Re: 2025/92872- Change of use from residential dwelling (Class C3) to children's care home (Class C2) with hip to gable alteration and erection of rear dormer at 24 Thornleigh Road, Crosland Moor, Huddersfield, HD4 5PY

Agnieszka Boryn
Designing Out Crime Officer
Kirklees District

PROPOSED SECOND FLOOR PLAN

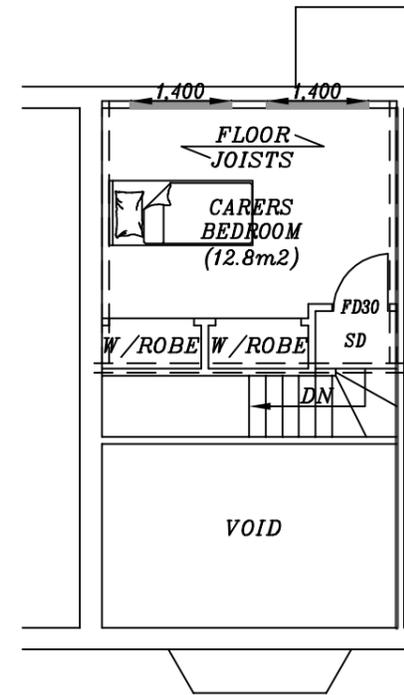
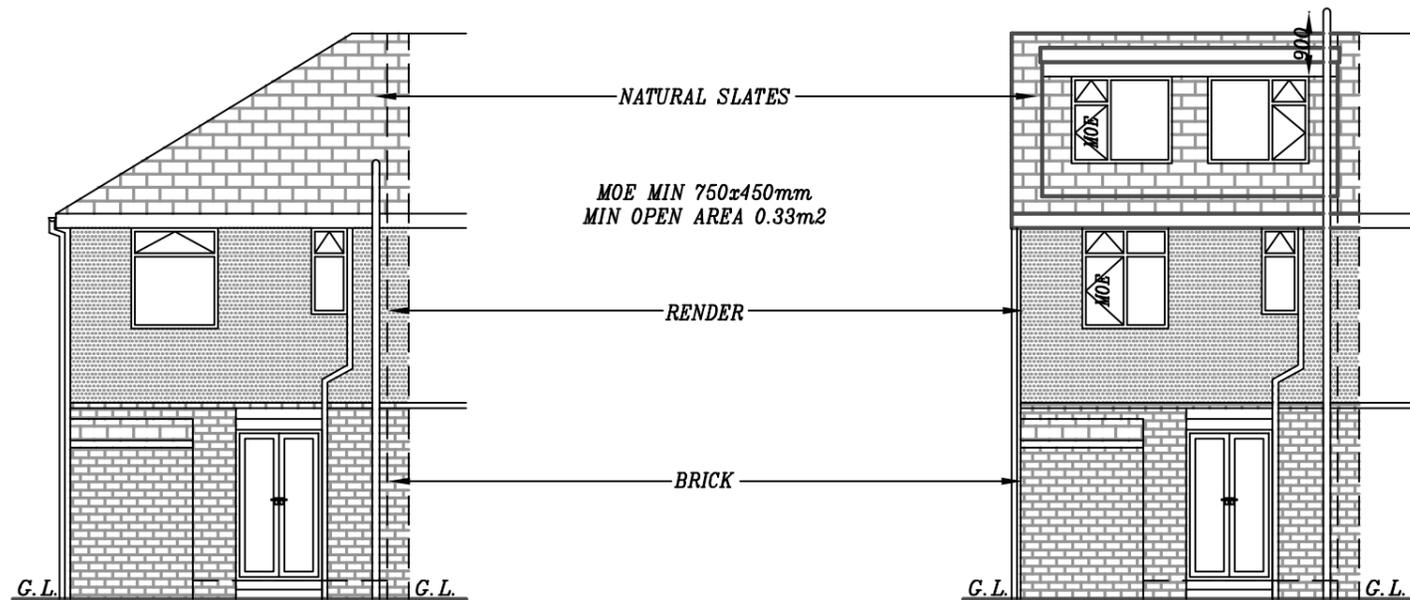
The proposal is to accommodate 2 children with social, emotional and behavioural difficulties. A minimum of 2 staff will be on duty at any given time. Floor plans indicate that during the night both staff members would be expected to share a 2nd floor bedroom while both children would stay on the 1st floor. I am not certain that this would be appropriate in terms of overnight supervision of 2 vulnerable children.
